From: Sue Howell
Sent: 18 July 2018 17:04
To: Planning.Responses
Cc: Anita Gardner
Subject: RE: Planning Consultation on FG/64/18/DOC

Comment from Greenspace

APPLICATION FG/64/18/DOC

Site Address: 44 Ferringham Lane Ferring BN12 5LU

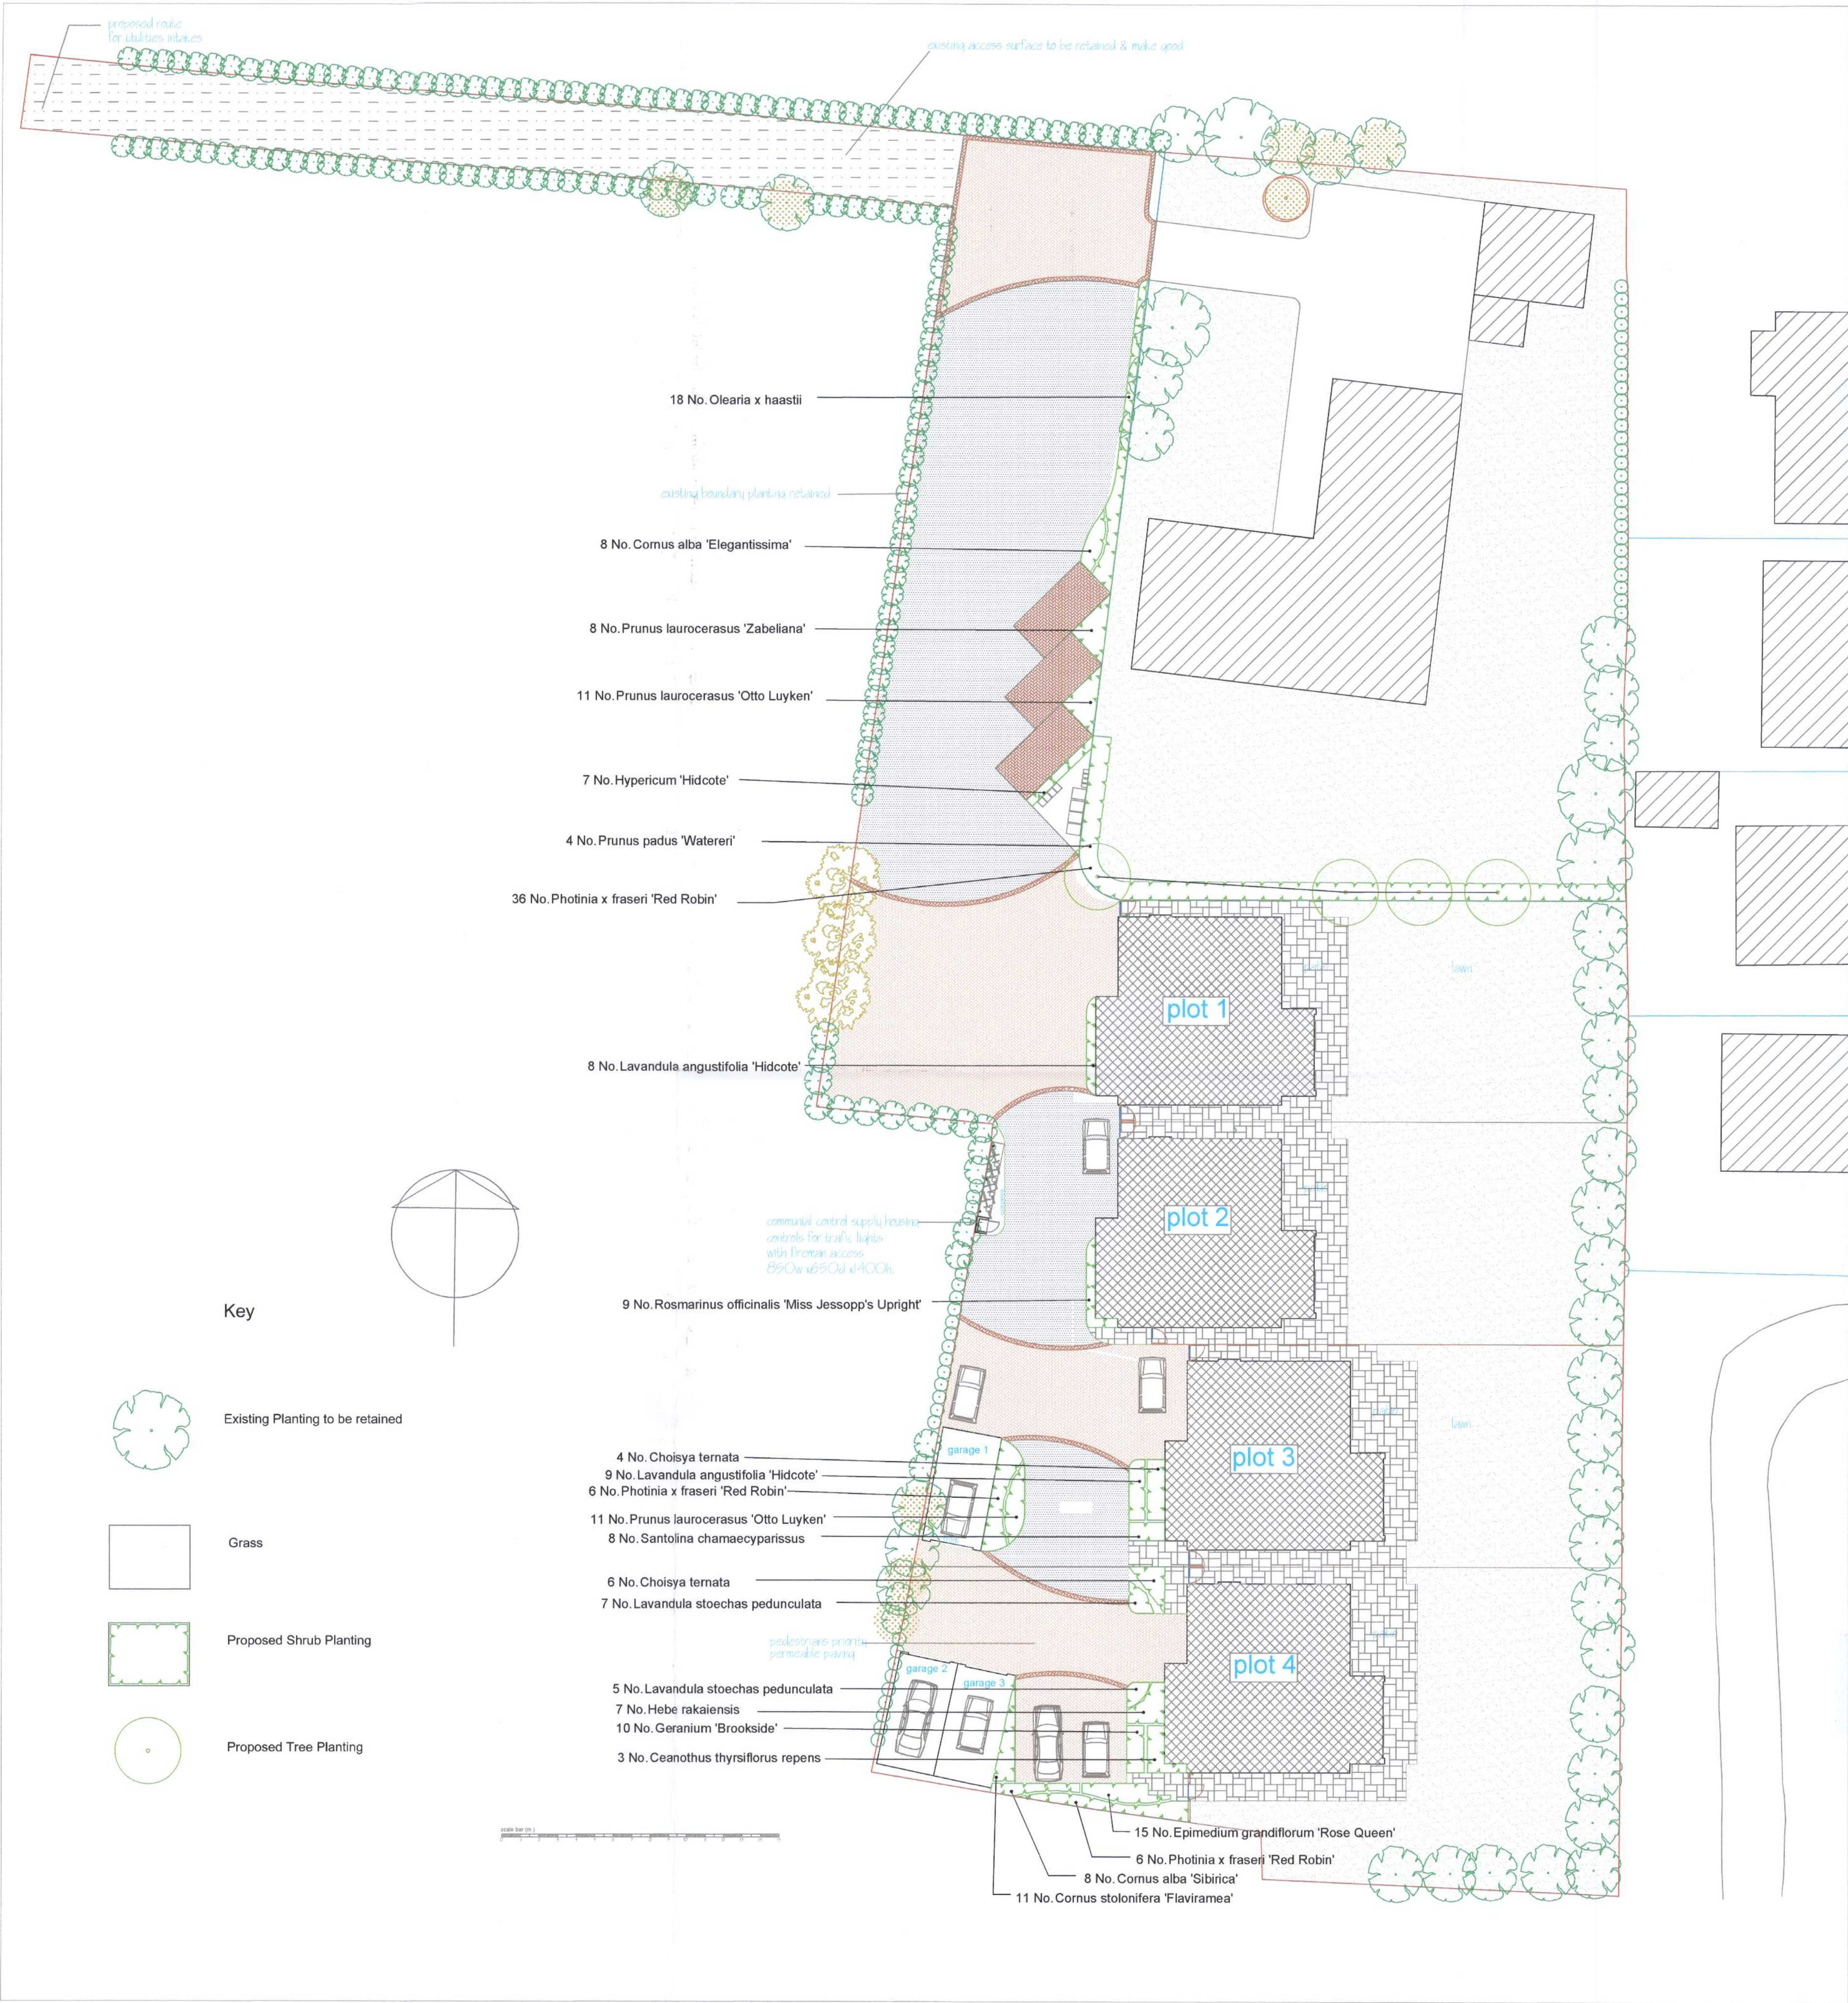
It is unclear from drawing no 731-L-01 planting Plan, where the 4no Prunus padus 'Wateri' EHS are to be located within the scheme. It was also a part of condition 8 that the existing tree protection detail be detailed for approval, which also appears to be missing from the Landscape proposals drawings.
